26th April 2021

Town & Country Planning Act 1990 (as amended)
Town & Country Planning (Development Management Procedure) (England) Order 2015

Application No: K/14/21/HH
Site Address: Peterley 45 Coastal Road Kingston BN16 1SN
Description of works: External staircase from first floor balcony to ground.

Drawing:
Proposed ground and first floor

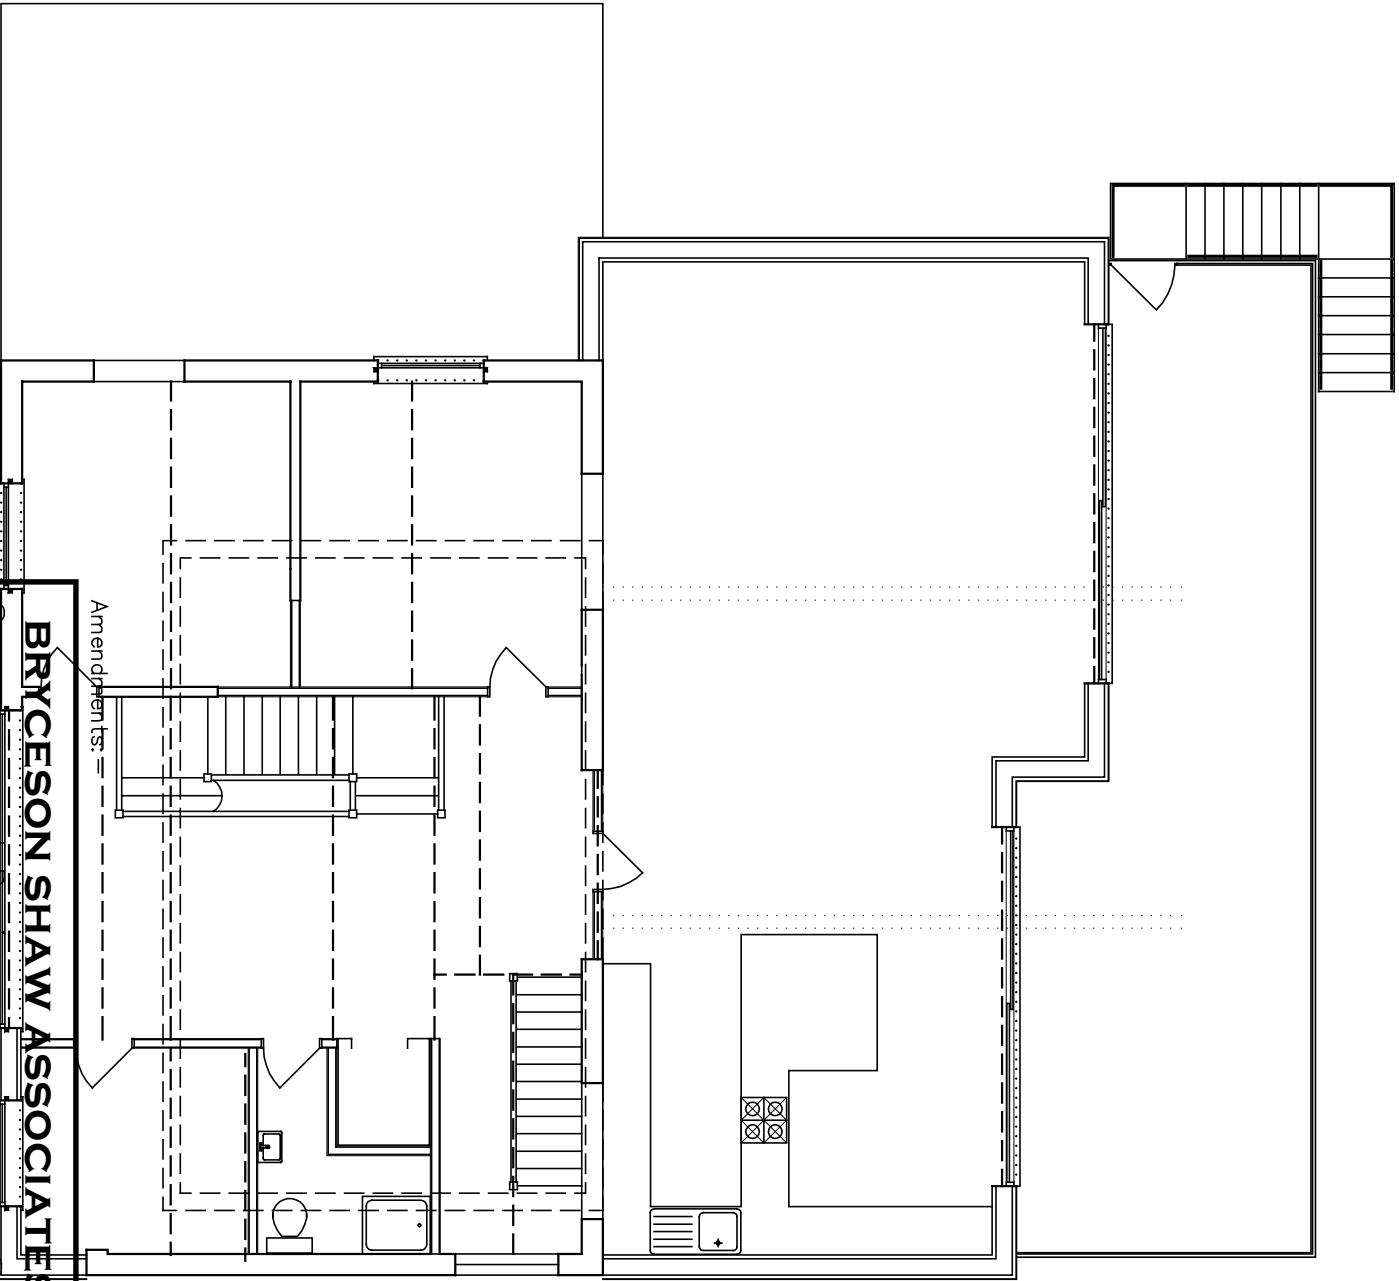
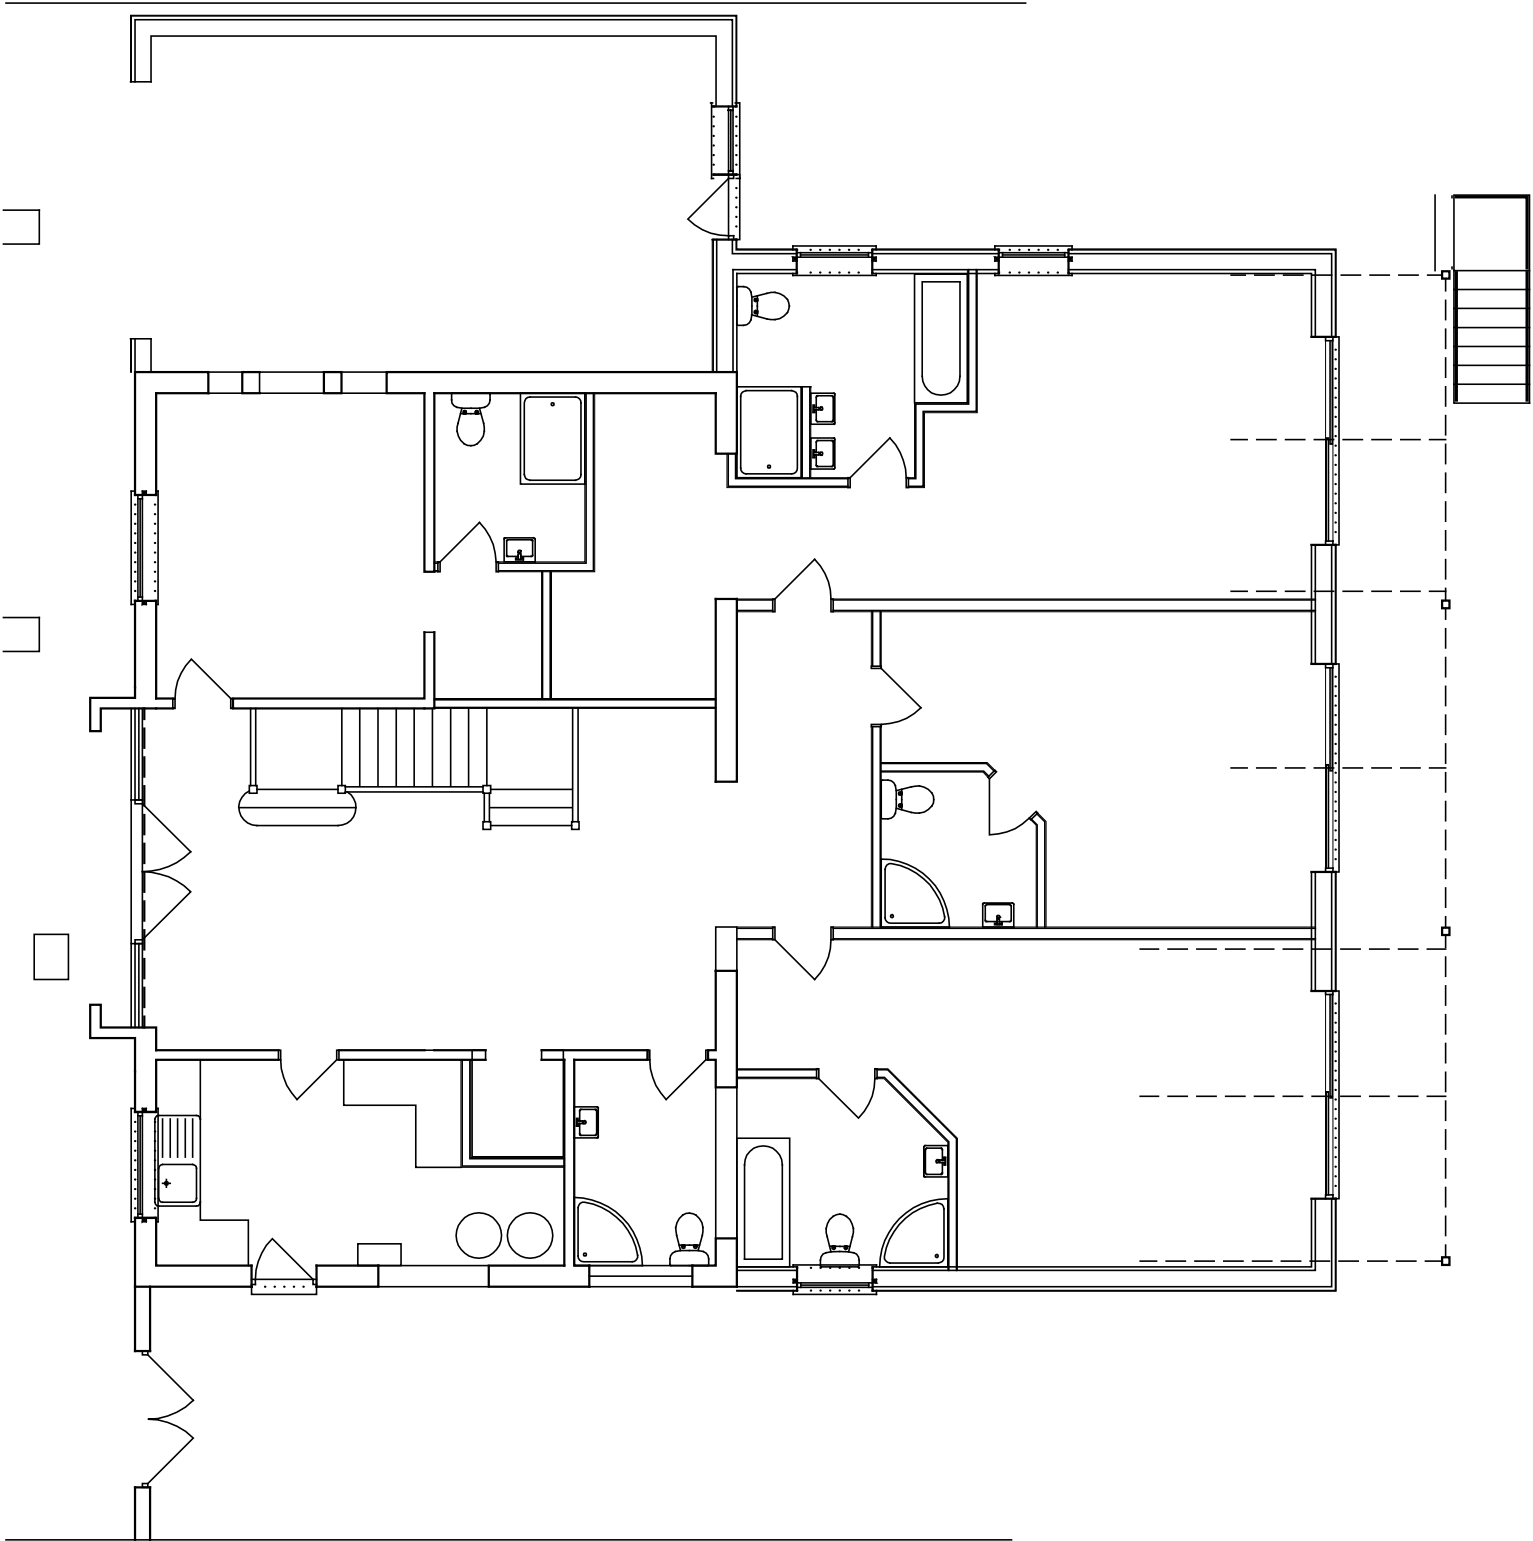
Council has no objection providing the case officer is satisfied that there is no undue overlooking from the proposed staircase and hence no conflict with conditions 3 and 4 relating to privacy screening imposed when planning application K/15/19/HH was approved.
